CITY OF ALBUQUERQUE

June 19, 2013

**Re: Alice Townhomes, 5600 Alice NE
Grading and Drainage Plan
Engineer's Stamp dated 5-04-13 (J18D043)**

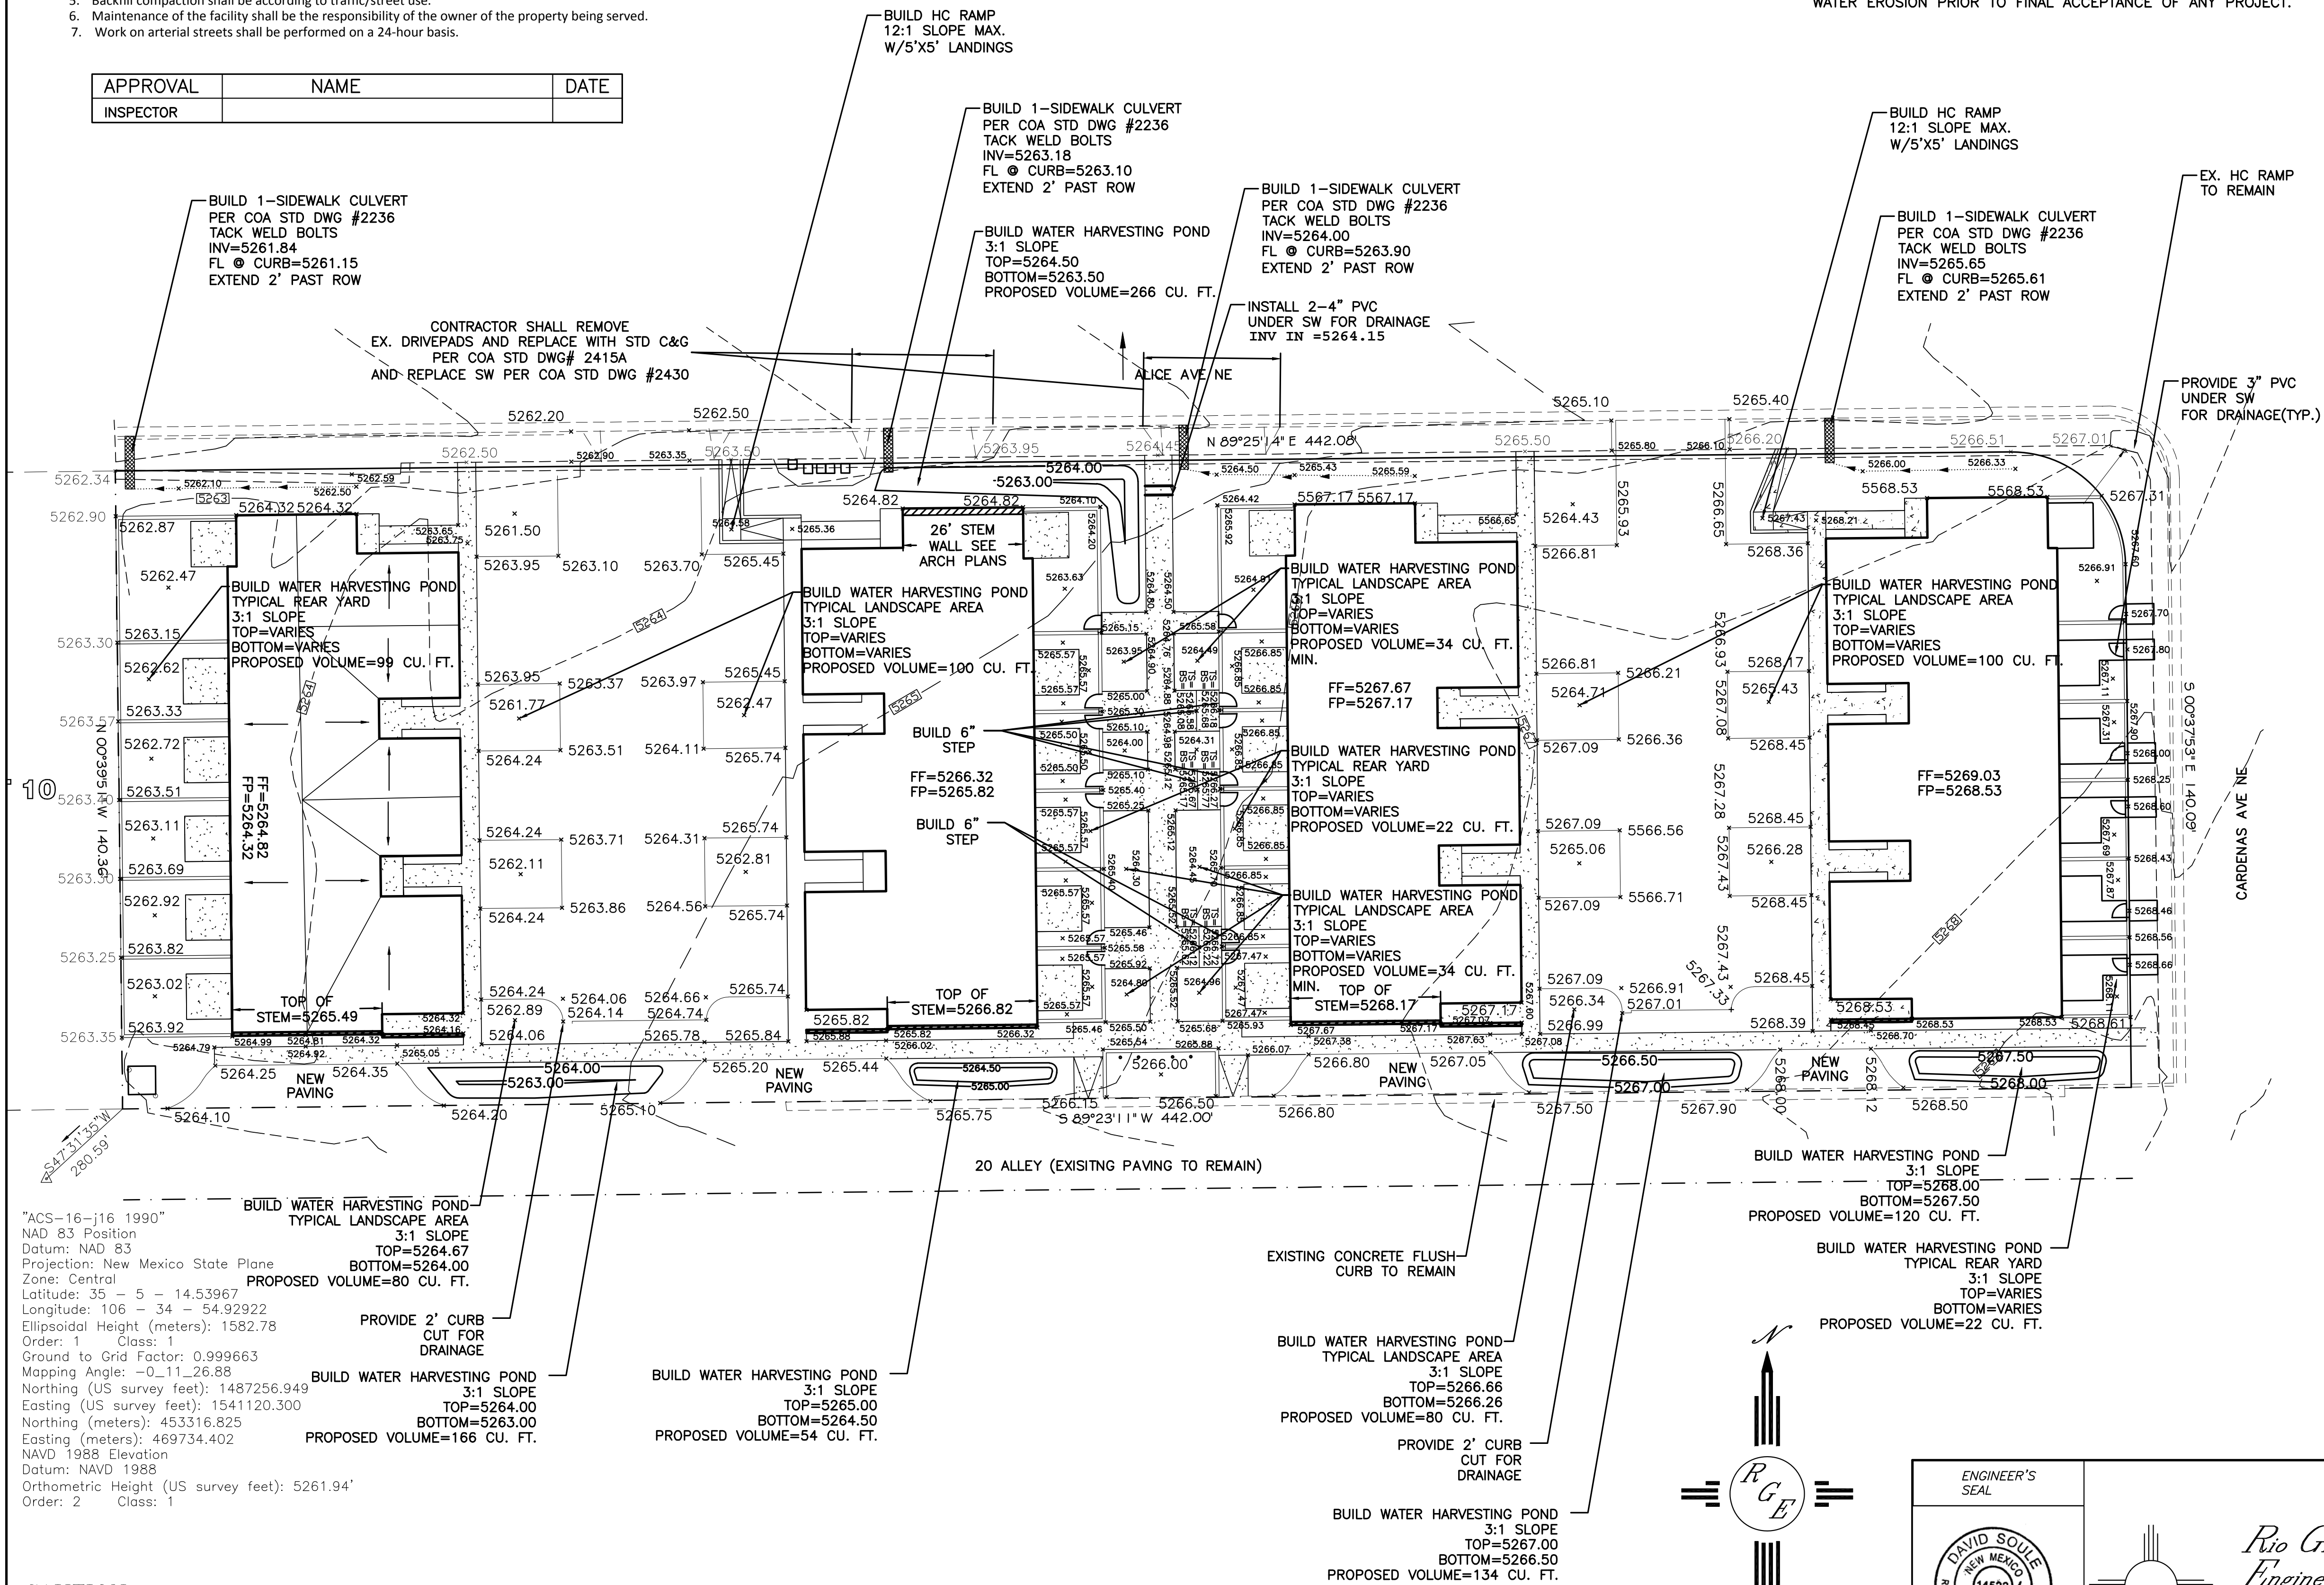
- Please make sure all on-site sidewalk connection into the City sidewalks meet ADA requirements.
- Add spot elevations at the entrances to assure adequate water block is provided.
- Sidewalks around the entrances will require public sidewalk easements.
- Extend sidewalk culverts 2' passed the property line.
- All entrances not used along Alice Ave. or Cardenas Ave. NE must be removed.
- Depress all landscaping areas where possible.
- Check the grades north side of the second building (from west to east). An extended stem wall will be needed.
- A utility box is shown on the sidewalk on Alison Ave. Is there ADA accessibility around the box?
- Concrete pads extended over the existing sidewalk along Cardenas Ave. must be removed.
- Clearly show the parking spaces along the alley. Does the alley have positive drainage to the west?
